EPC STORMWATER REVIEW COMMENTS
IN ORANGE BOXES WITH BLACK TEXT

TRAILS AT ASPEN RIDGE FILING NO. 5

FINAL GRADING & EROSION CONTROL PLANS

OCTOBER 2021

TRAILS AT ASPEN RIDGE- F5				
GRADING AND EROSION CONTROL PLAN				
TITLE SHEET				
DESIGNED BY:	CRD	SCALE	DATE ISSUED:	DRAWING No.
CHECKED BY:	NMS	HORIZ. N.A. VERT. N.A.	OCTOBER 2021 SHEET 1 OF 7	TS01

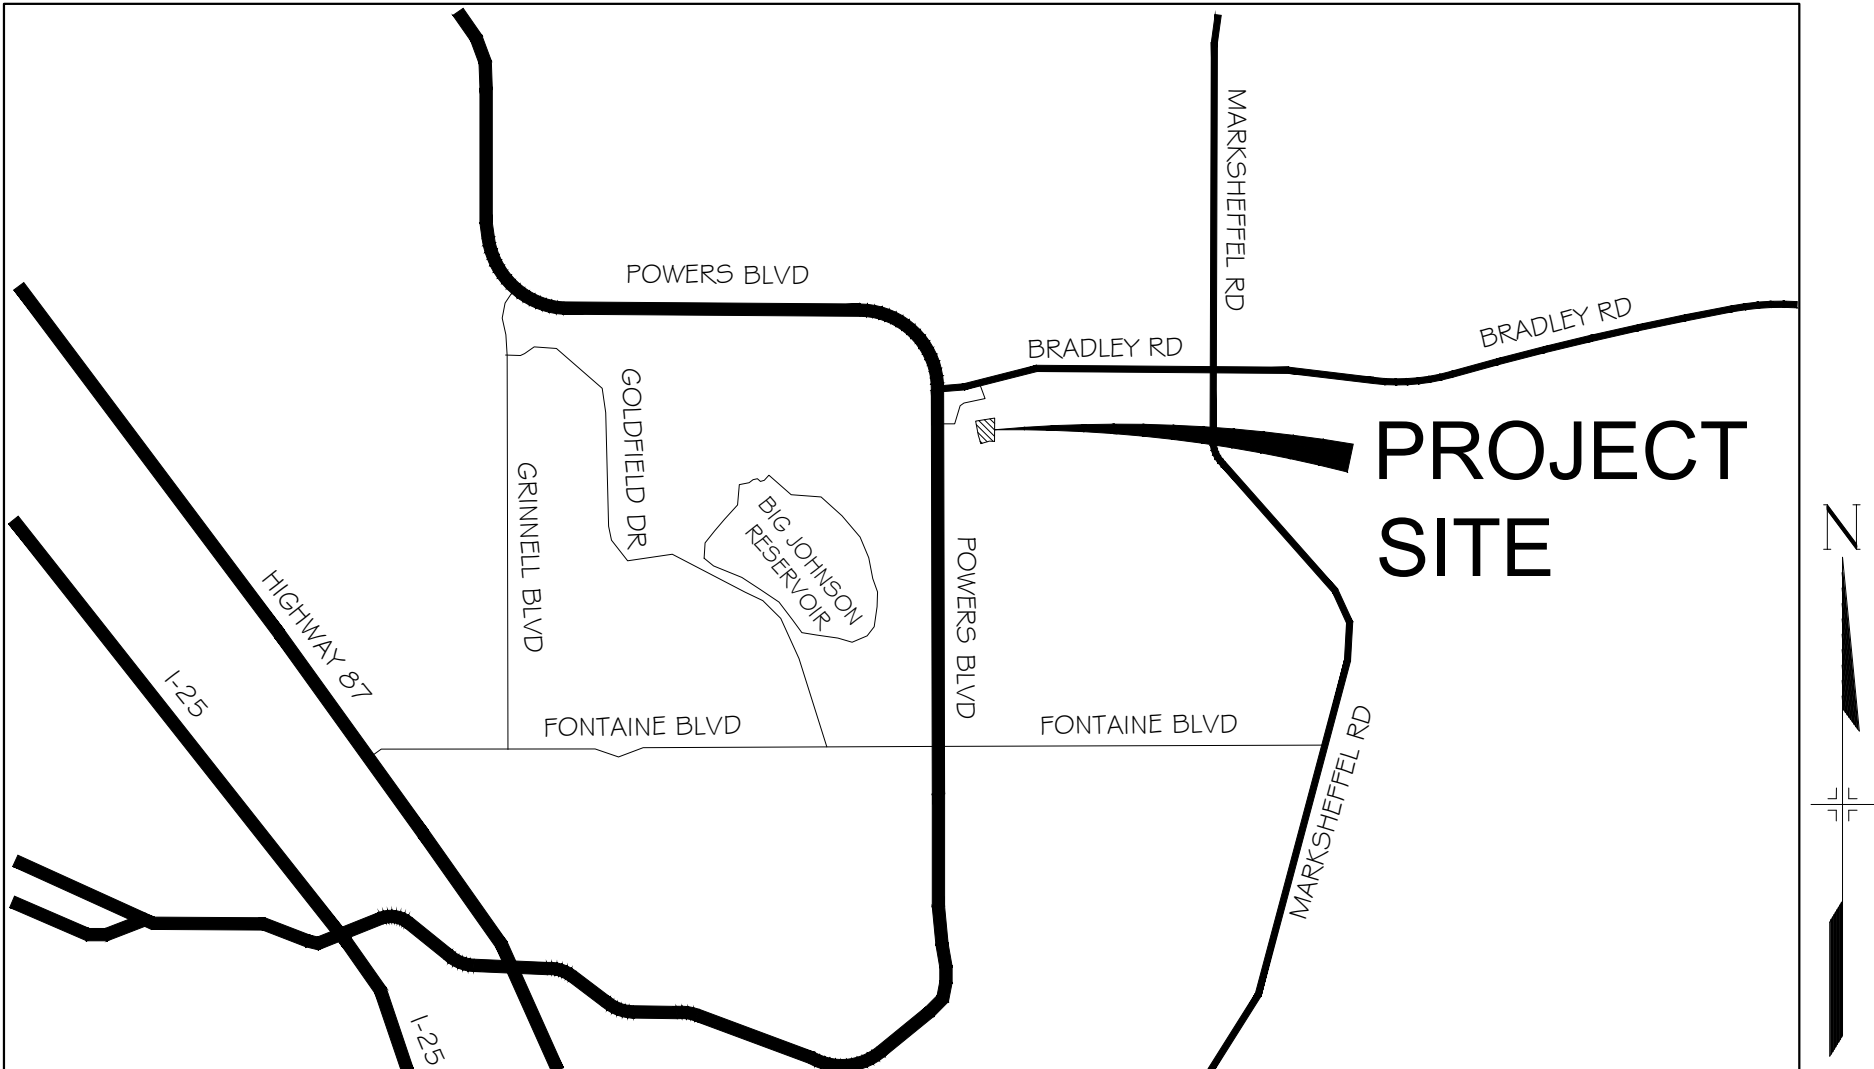
Add PCD File No SF-21-038
